Application for a Non-Material Amendment Following a Grant of Planning Permission

Demolition of existing store, shed and garage; construction of two storey side extension; erection of detached garage and loft extension with accommodation in the roofspace served by front/rear dormer windows and front rooflight, relocation of entrance door, front porch canopy, rear juliet balconies, alterations to fenestrations detail including replacement of doors and windows, internal alterations with associated front/rear landscaping works including alterations and extension to driveway.

23/1401/FUL

Blocking up small window in the Kitchen

The Contractor, and all specialist Sub-contractors are to check all levels, dimensions and features on site prior to performing any element of work or installations. Any and all discrepancies are to be reported immediately to MD Designs for decision.

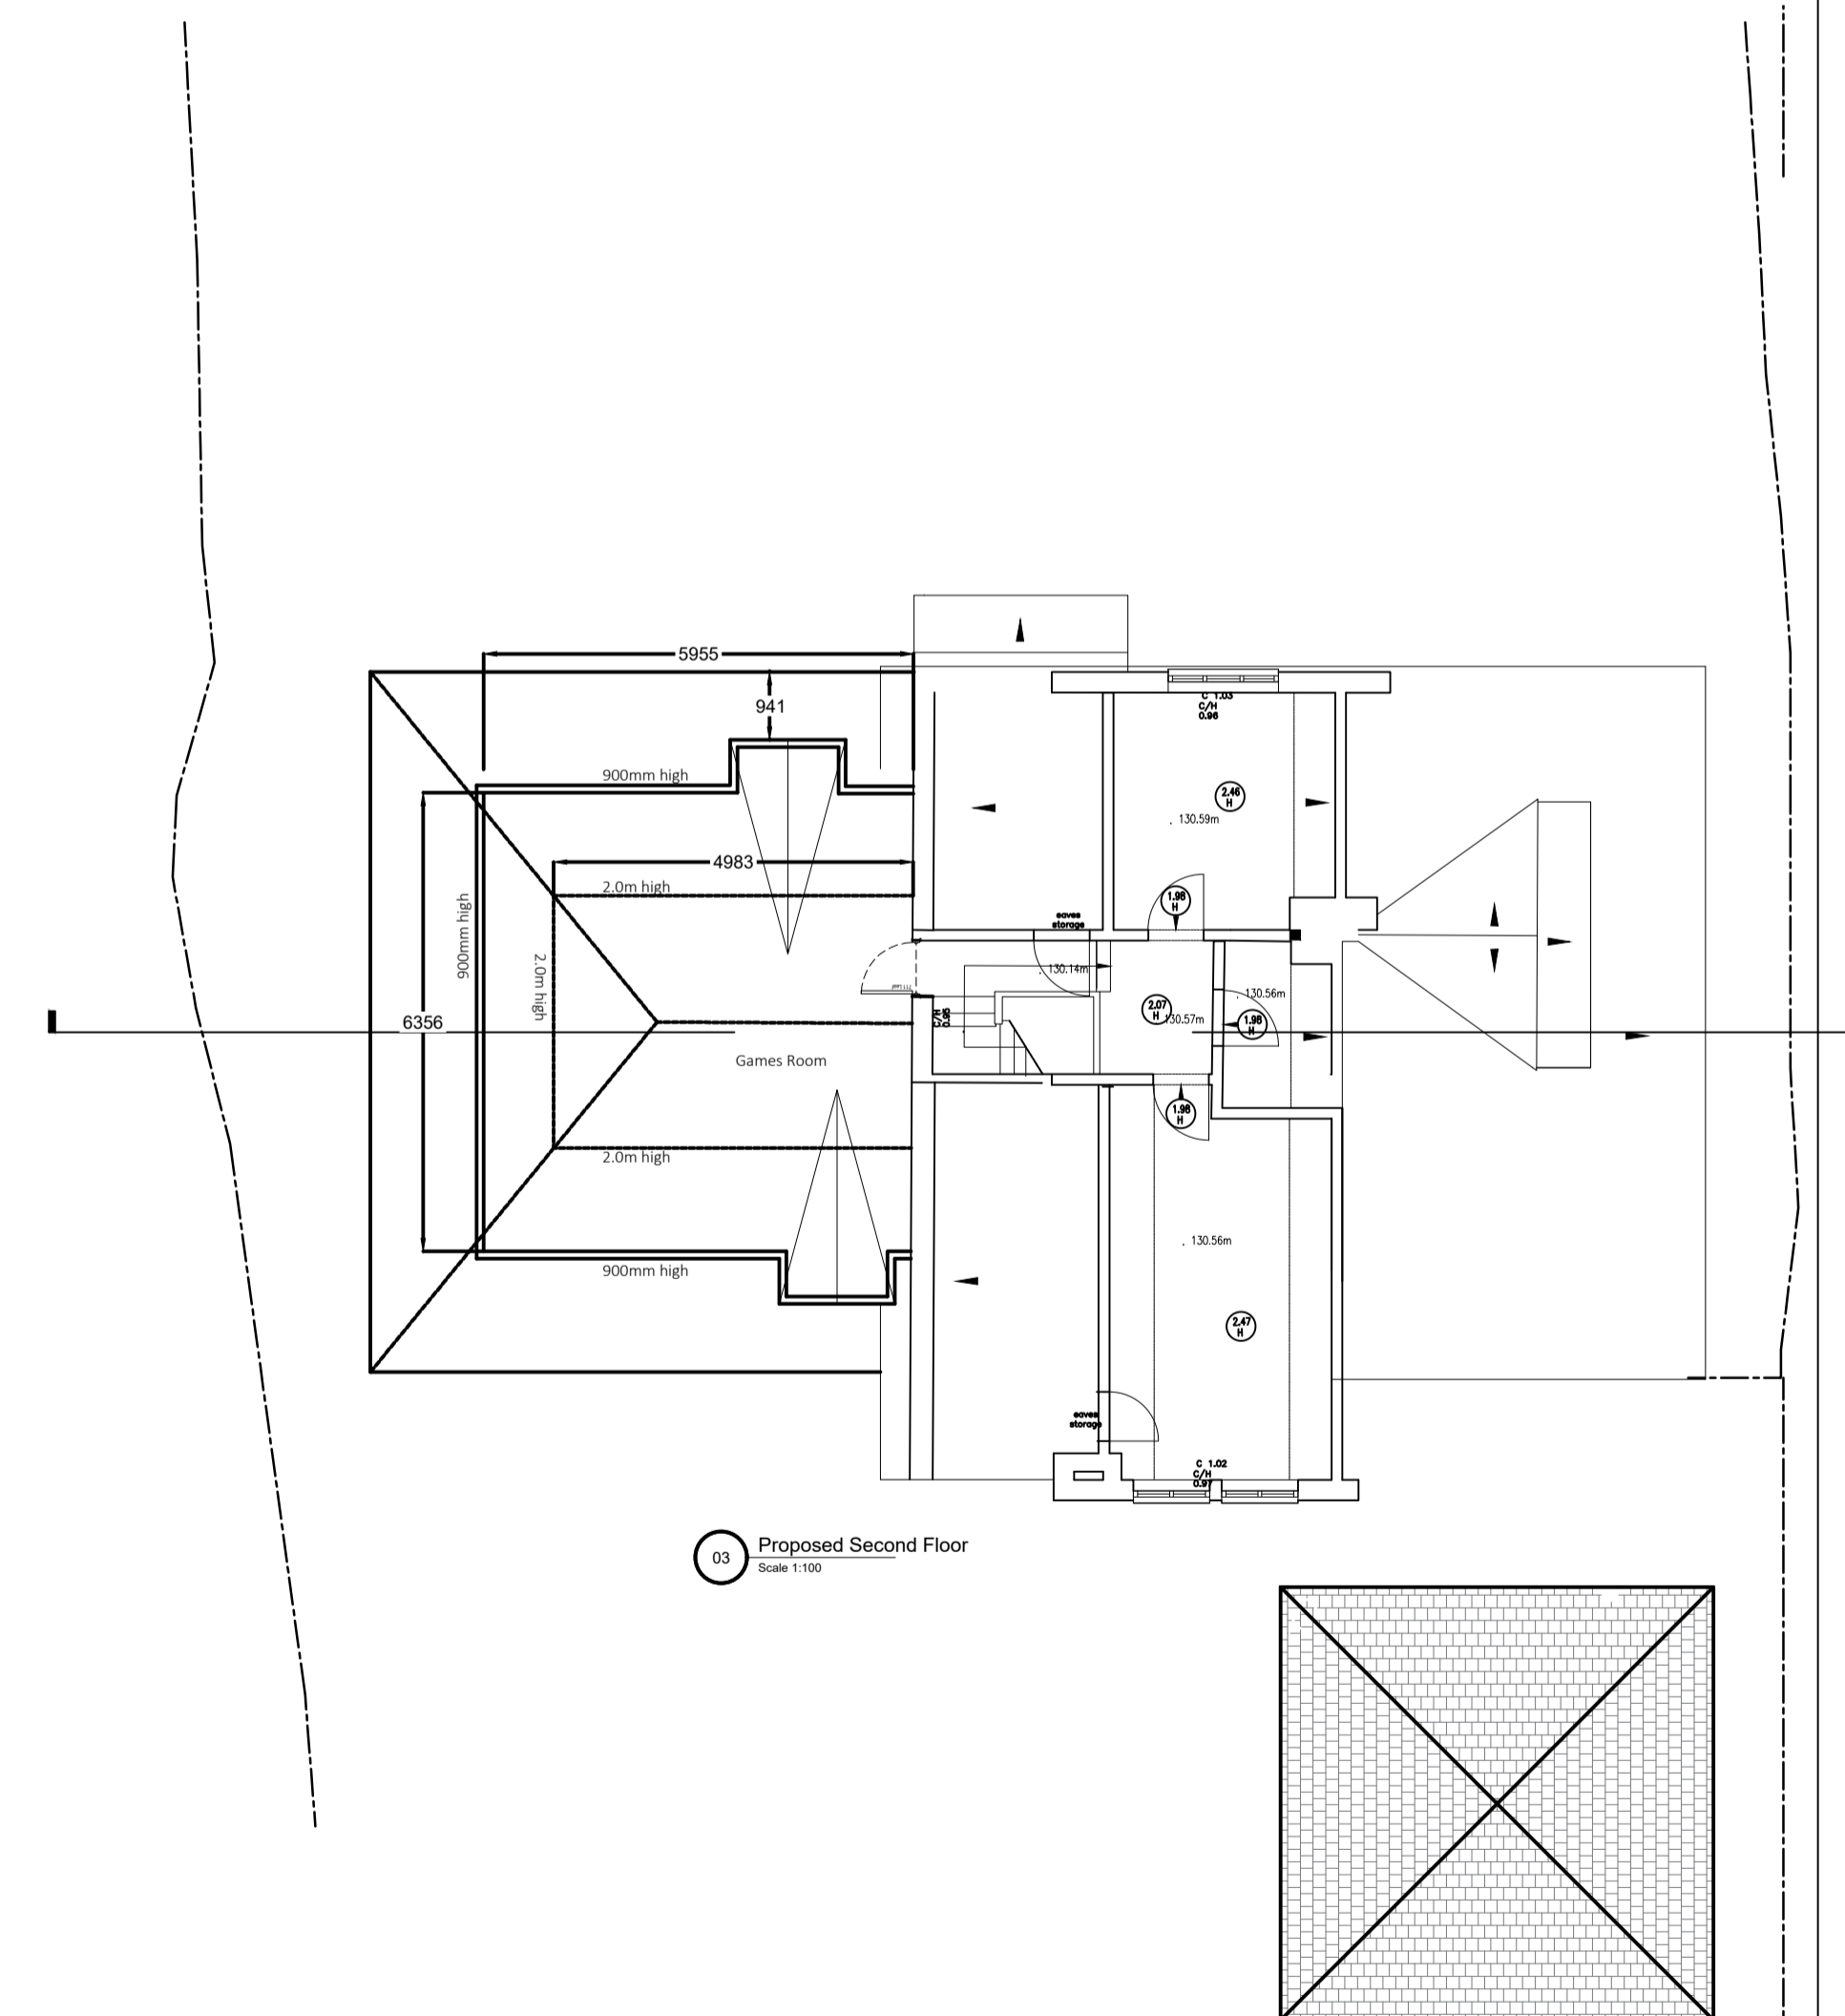
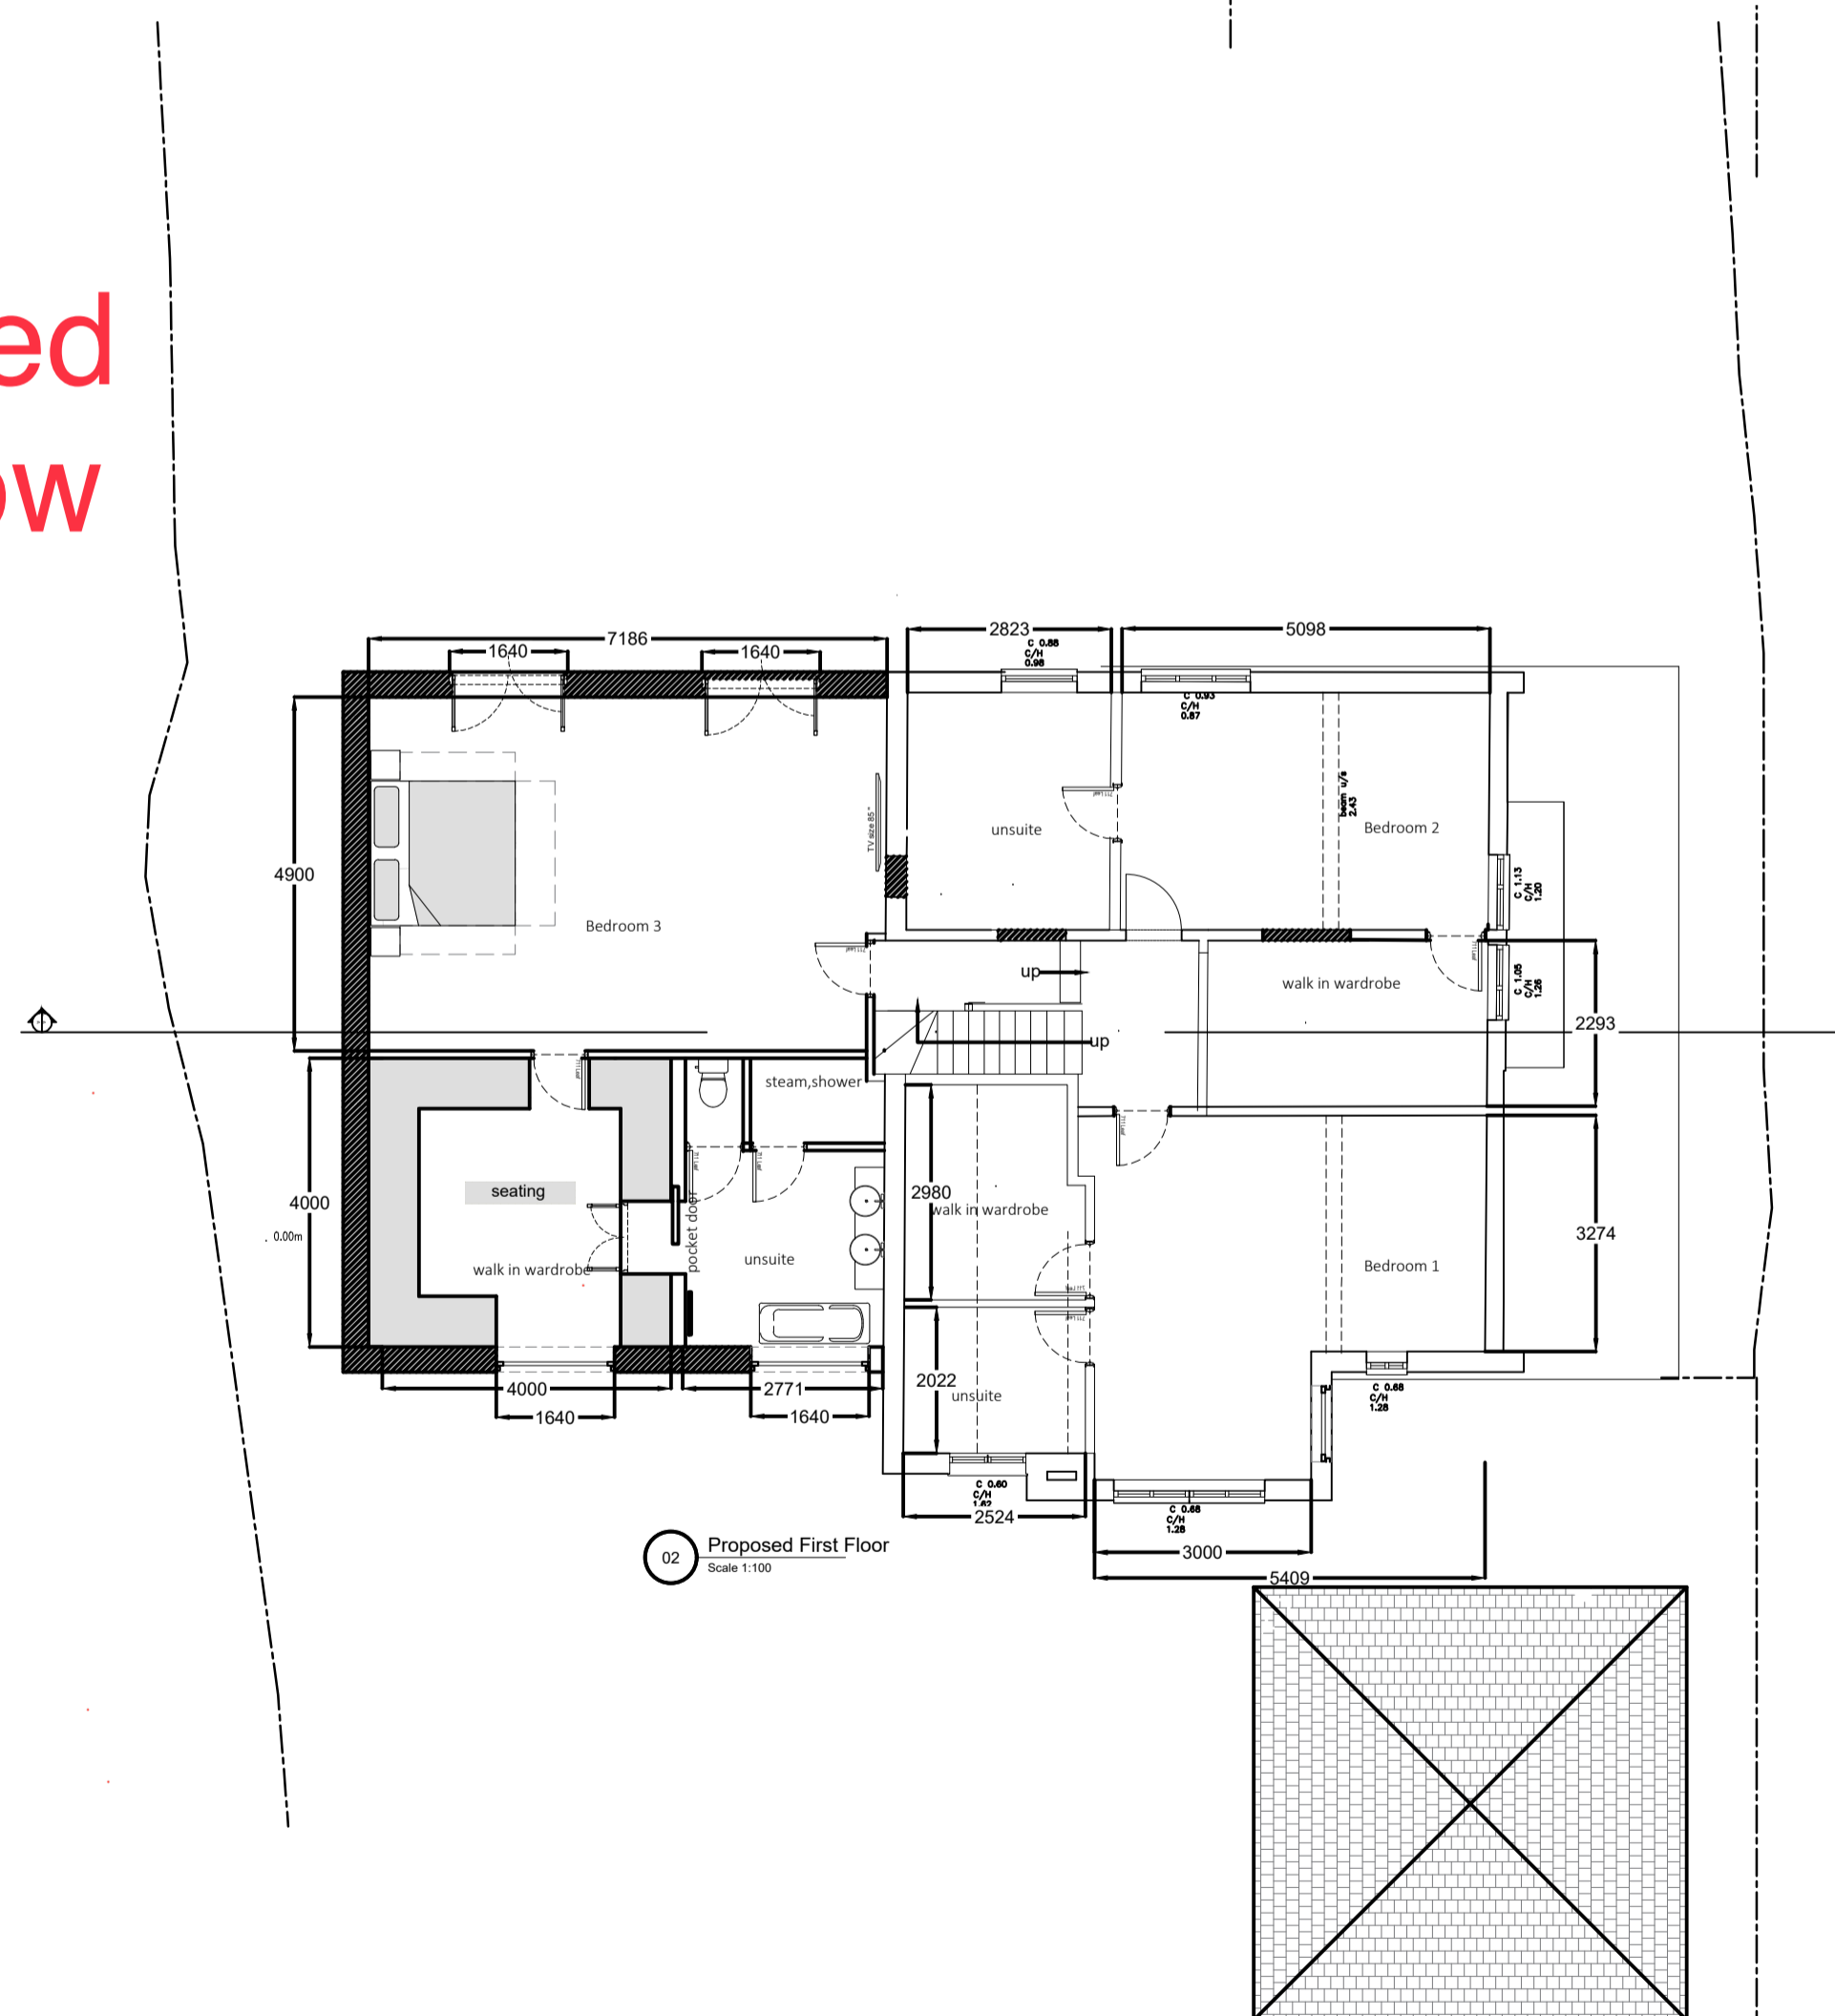
To allow for a better kitchen layout. The kitchen already benefits from a 5m wide floor to ceiling sliding doors to garden so there is plenty of light.
